Date: 03 October 2022

Application by Equinor for an Order Granting Development Consent for the Sheringham and Dudgeon Extension Project

Advice following issue of decision to accept the application for Examination

Title: Figure 18.2.14 Onshore Substation Site - Flood Zones

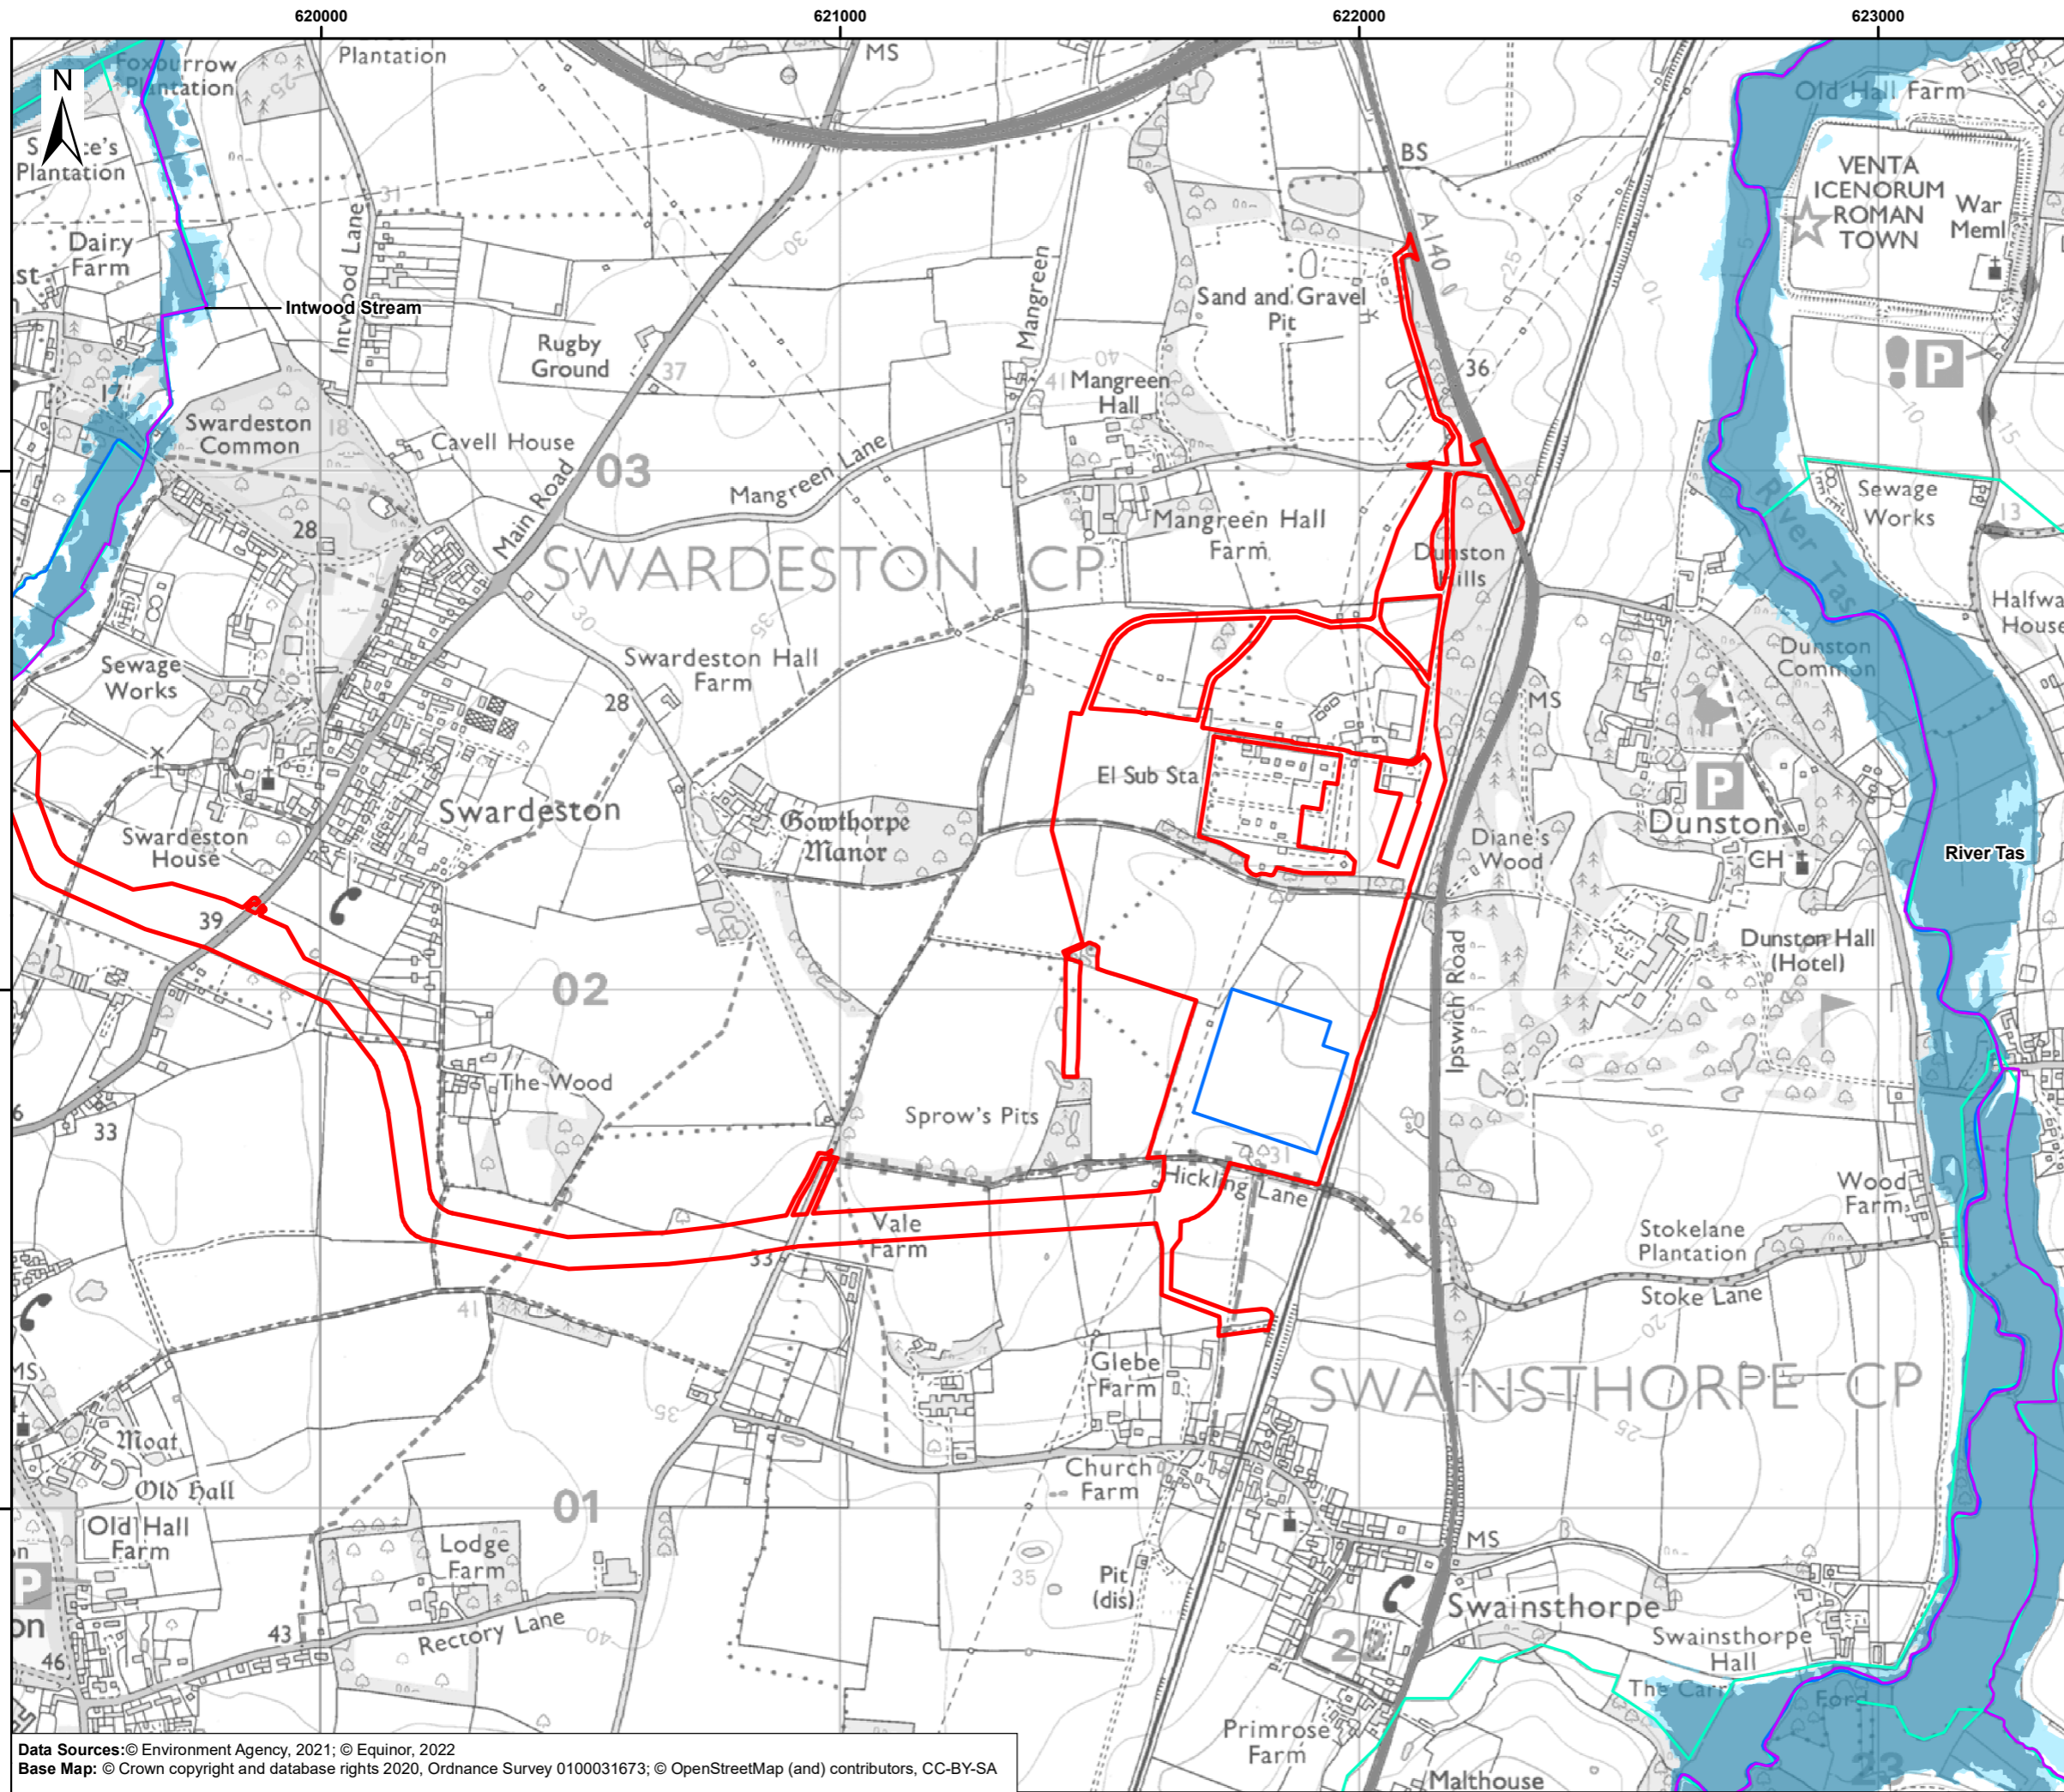
Although the Flood Risk Assessment is considered to be adequate at this stage, Figures 18.2.2 - 18.2.15 (inclusive) appear to have been omitted from the document. It is suggested that these documents are submitted as soon as possible, before the commencement of the Examination, so they are available with all other application documents in advance of submissions of Written Representations and Local Impact Reports.
